File Ref. No: BFS16/1540 (11099)
 TRIM Doc. No: D16/64949
 Contact: Station Officer C. Wheatley

22 August 2016

**Environmental Impact Statement
 Mortdale Resource Recovery Facility (SSD 7421)
 20 Hearne Street Mortdale**

Fire and Rescue NSW (FRNSW) have reviewed the EIS, including various Appendices, in particular, Appendix L – Preliminary Hazard Analysis (PHA), *SEPP 33 Preliminary Risk Screening & Hazard Assessment*. The PHA has been prepared by SLR Consulting Australia Pty. Ltd. Reference 610.14692.-R0 – Revision 0, dated 12 April 2016. FRNSW note that the primary purpose of the facility is for waste storage and processing of general mixed waste.

Plan No.
SY16043C101
File Ref.
SY16043C_E.dwg
SHEET 1 OF 4 SHEETS
REV. **E**

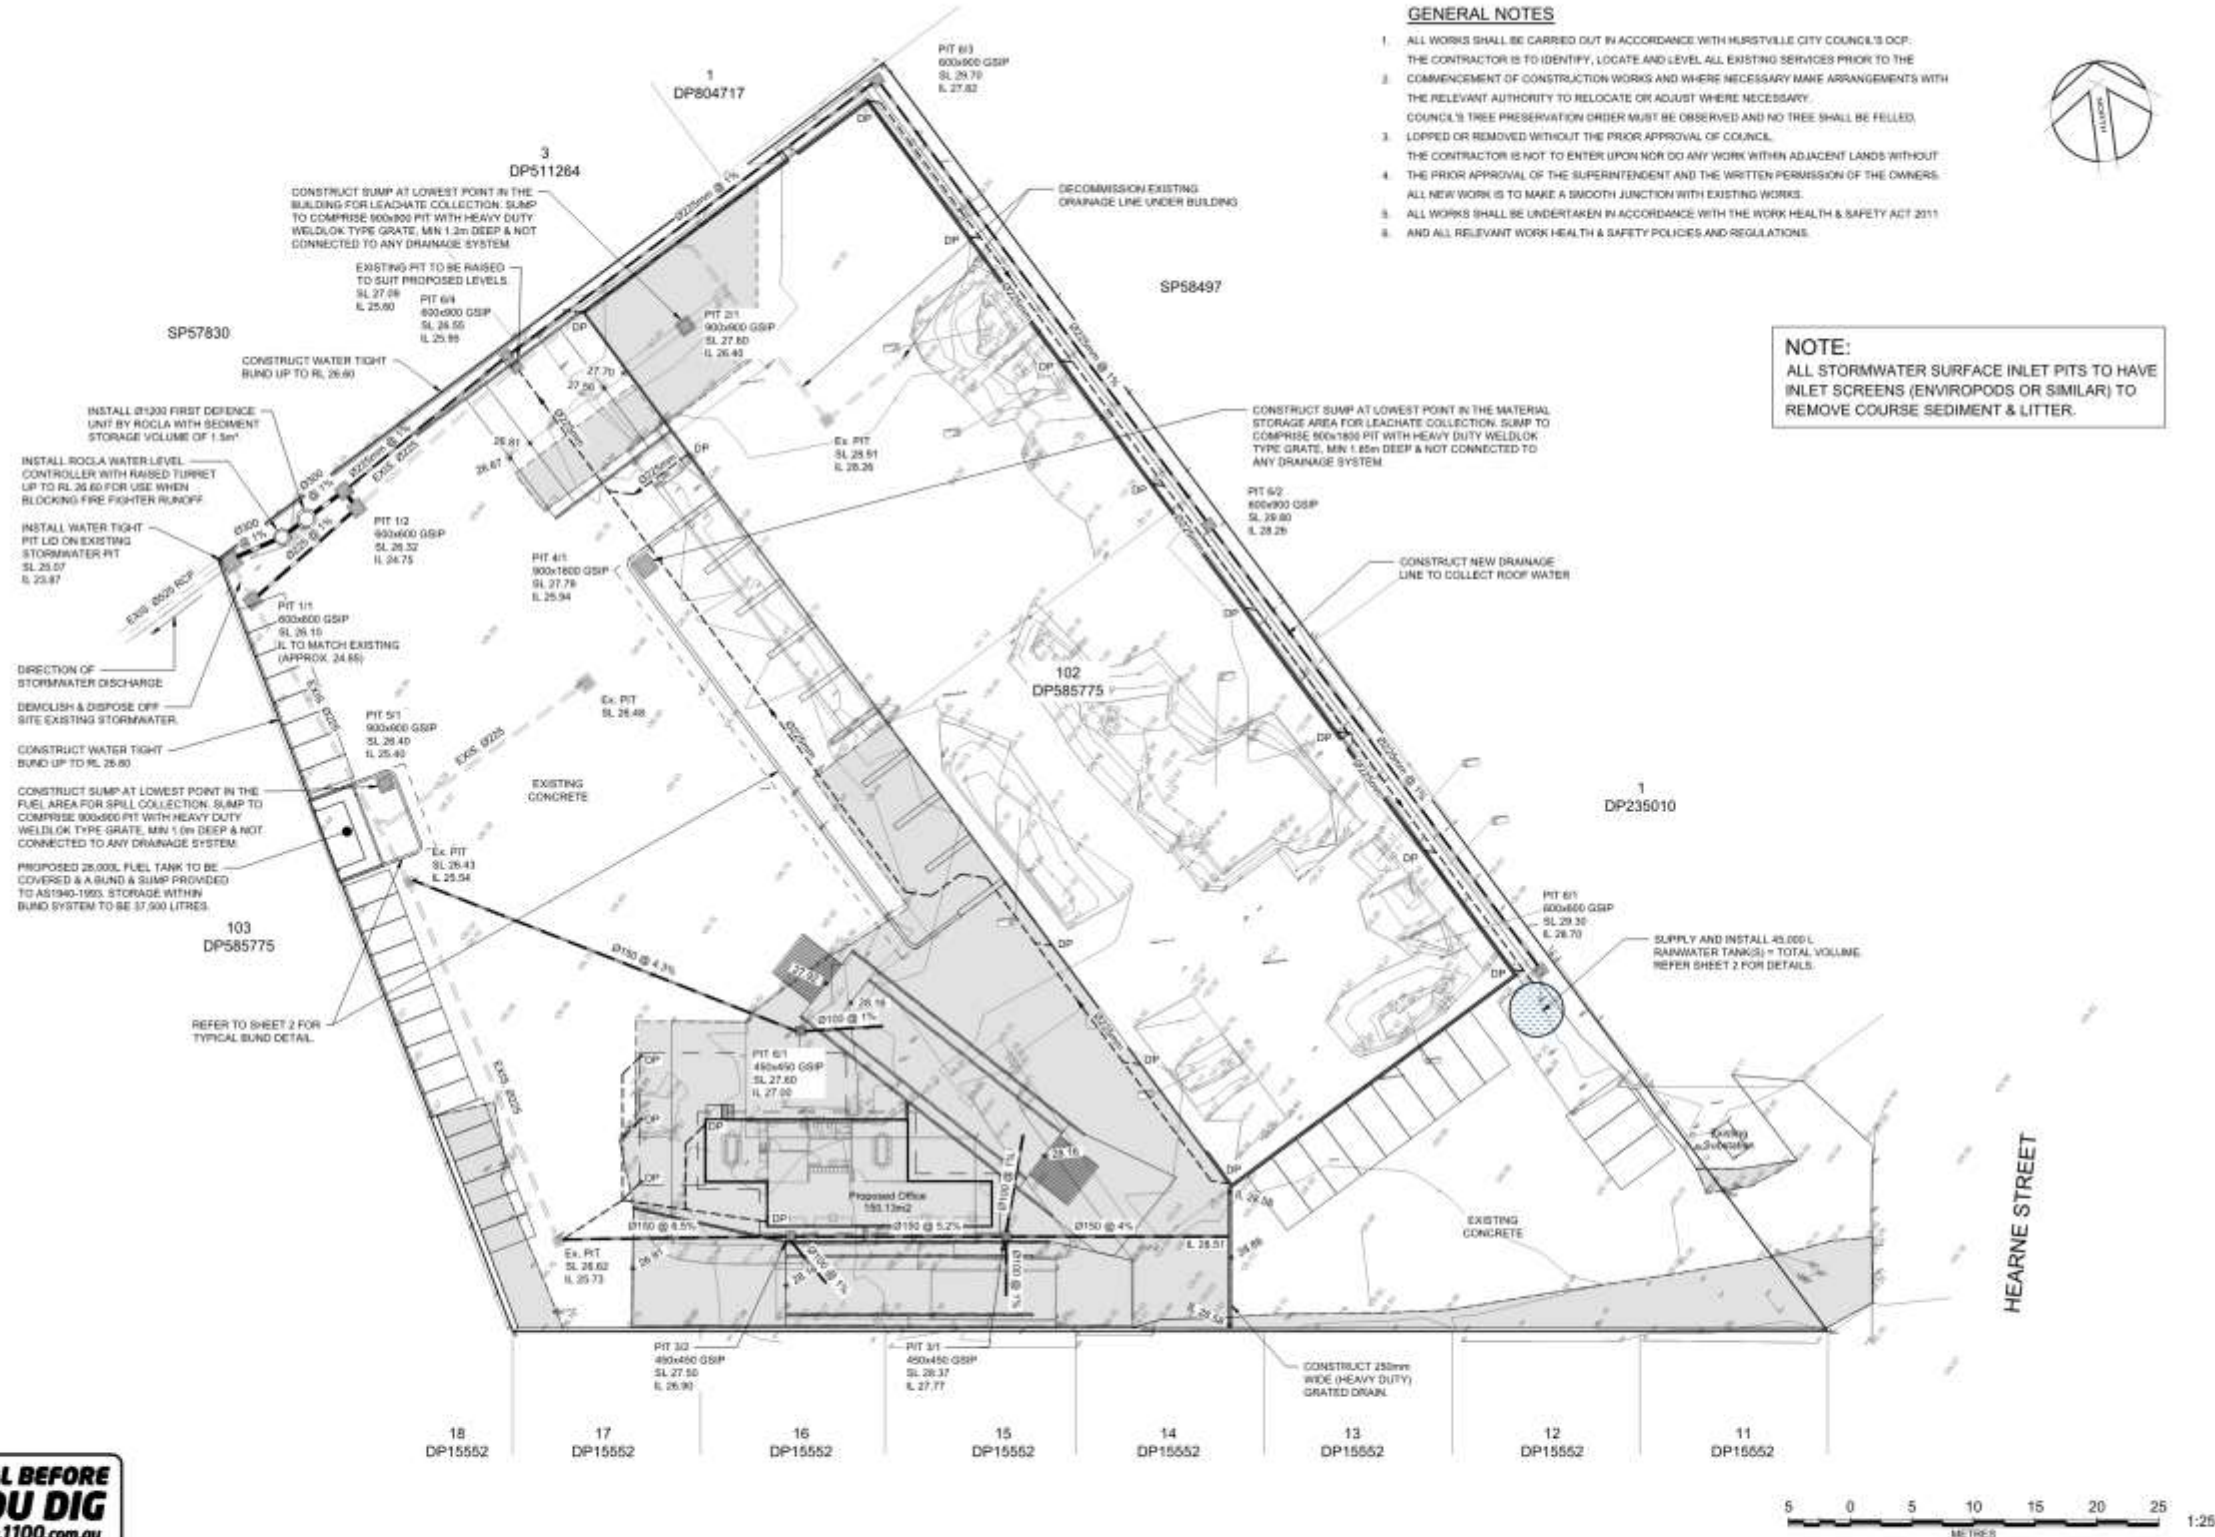
1. FRNSW considers the proposed storage of Dangerous Goods as detailed within detailed drawing numbers 151045 – 03.2/18 EIS – Revision I and SY16043c101 – Revision E, in conjunction with the information provided within part 6.4.1 of the EIS, to be inconsistent. FRNSW recommends that the proposed storage provisions, fuel dispensing, tank vehicle loading provisions and fire protection for the proposed stored Dangerous Goods be clarified and in accordance with Australian Standard AS 1940 – 2004.
2. FRNSW considers the proposed increase in materials to be stored and processed at the facility to represent a realistic possibility for a high fire load and fire hazard with the potential for problematic firefighting operations. Such an incident at the facility would require significant resource commitment by FRNSW in order to ensure safe resolution of the fire incident.
